Current Zoning: UR-2(CD) (Urban Residential, Conditional), N2-B (Neighborhood Residential)
 Proposed Zoning: UR-2(CD) (Urban Residential, Conditional), UR-2(CD) SPA (Urban Residential, Conditional, Site Plan Amendment)

Approximately 7.01 acres located south of Alleghany Street, west of Ashley Road, and north of Bullard Street.

The petition proposes to amend a previously approved plan to allow a community of 123 single family attached dwelling units in the Ashley Park neighborhood.

EXISTING CONDITIONS PLAN AND TECHNICAL DATA SHEET
 REZONING PETITION: 2023-043

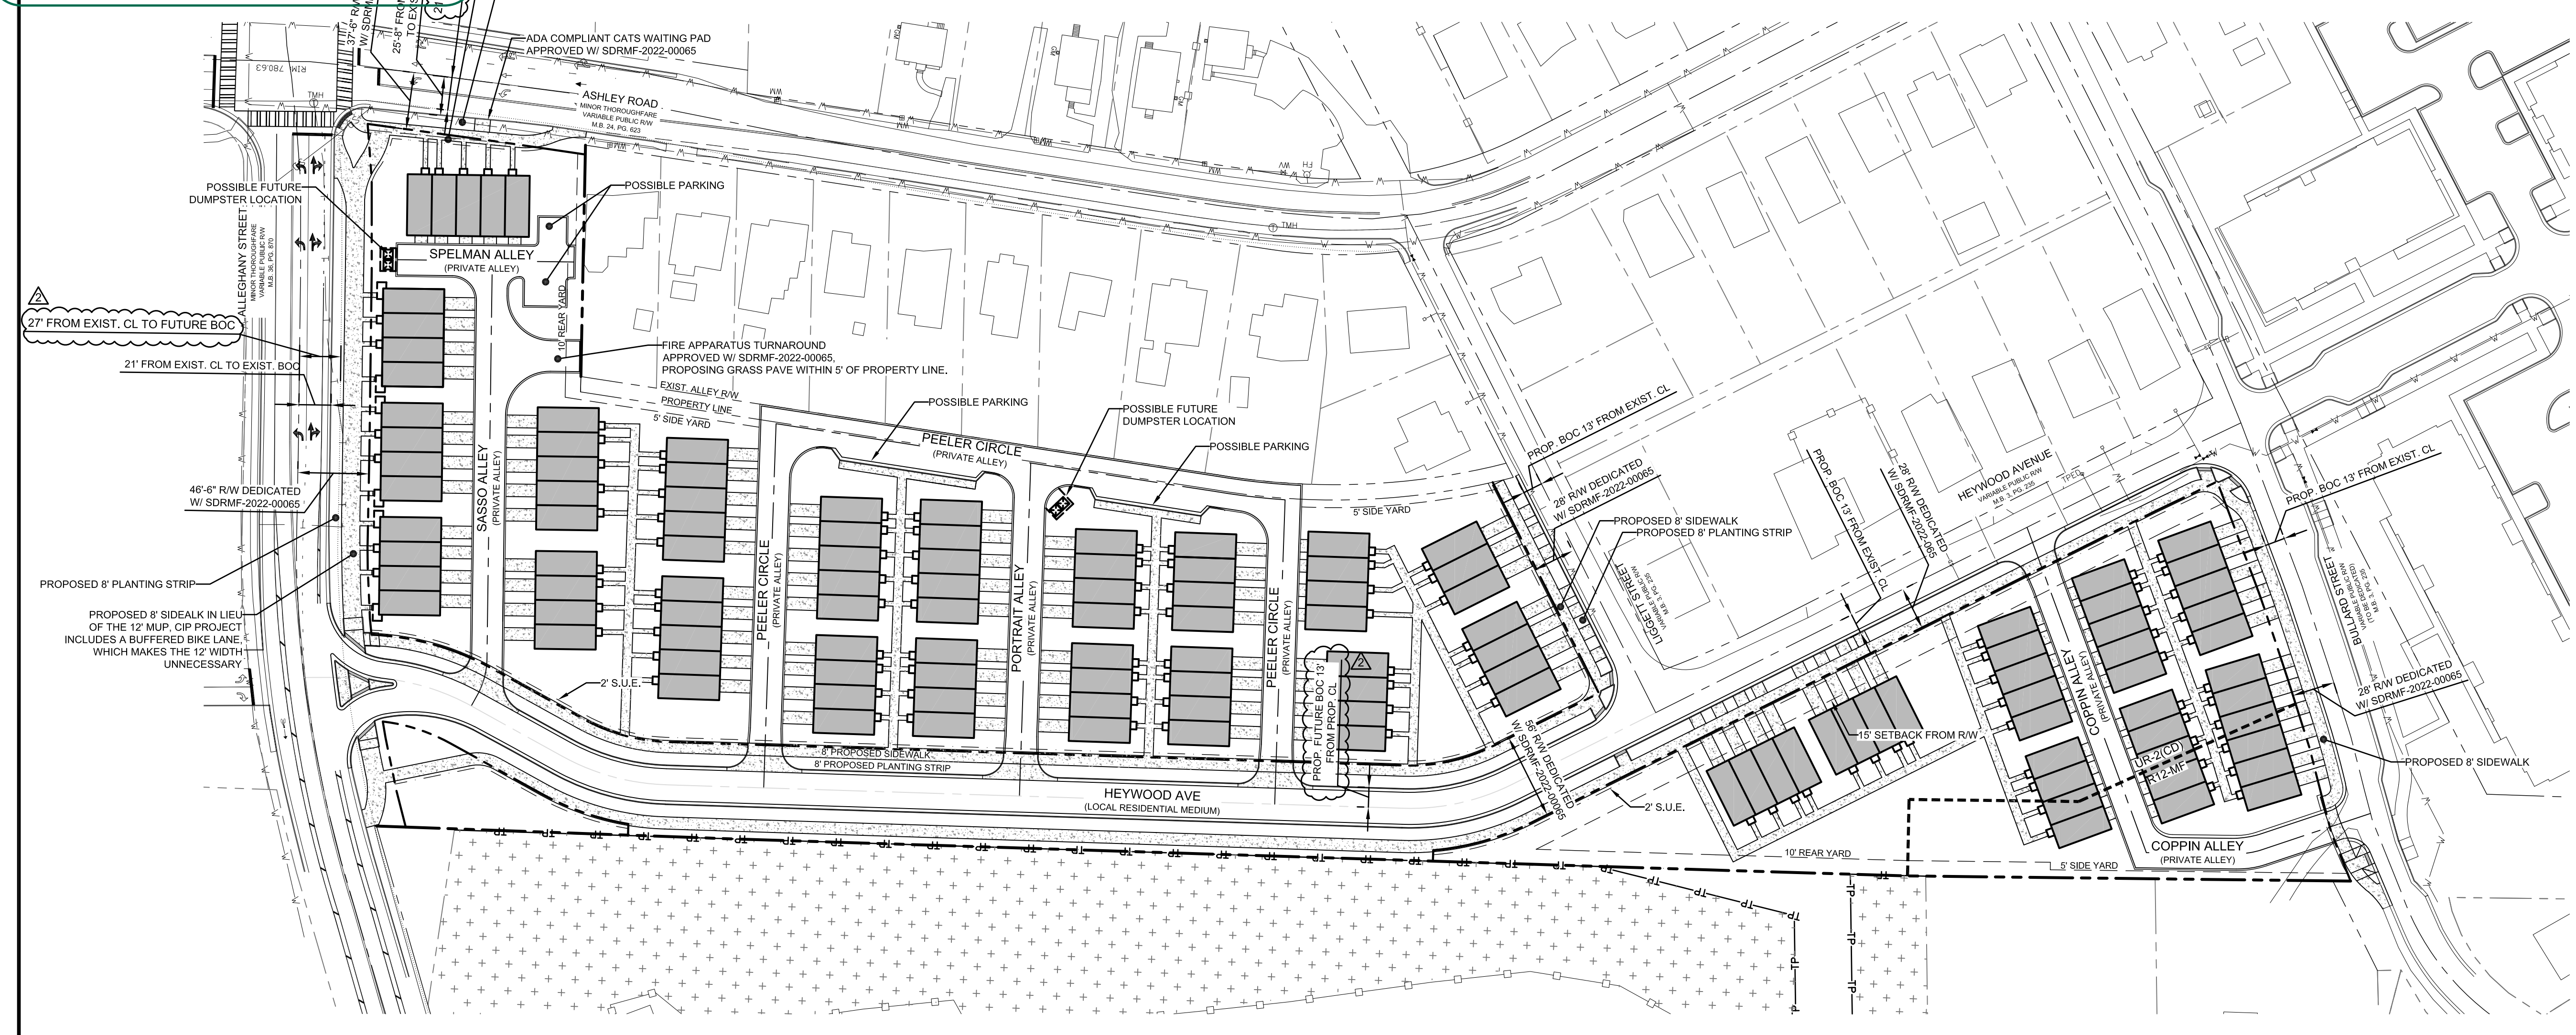
1. Label and dimension the future curb and gutter from the centerline for each road on the site plan.
2. Add a conditional note specifying "A Right-of-Way Encroachment Agreement is required for the installation of any non-standard item(s) (irrigation systems, decorative concrete pavement, brick pavers, etc.) within a proposed/existing City-maintained street right-of-way by a private individual, group, business, or homeowner's/business association. An encroachment agreement must be approved by CDOT prior to construction/installation. Contact CDOT for additional information concerning cost, submittal, and liability insurance coverage requirements."

4. Revise site plan and conditional note(s) to remove the fence completely from the public alley and onto private property. If fence is to remain along the single family home side it needs to be completely on private property.
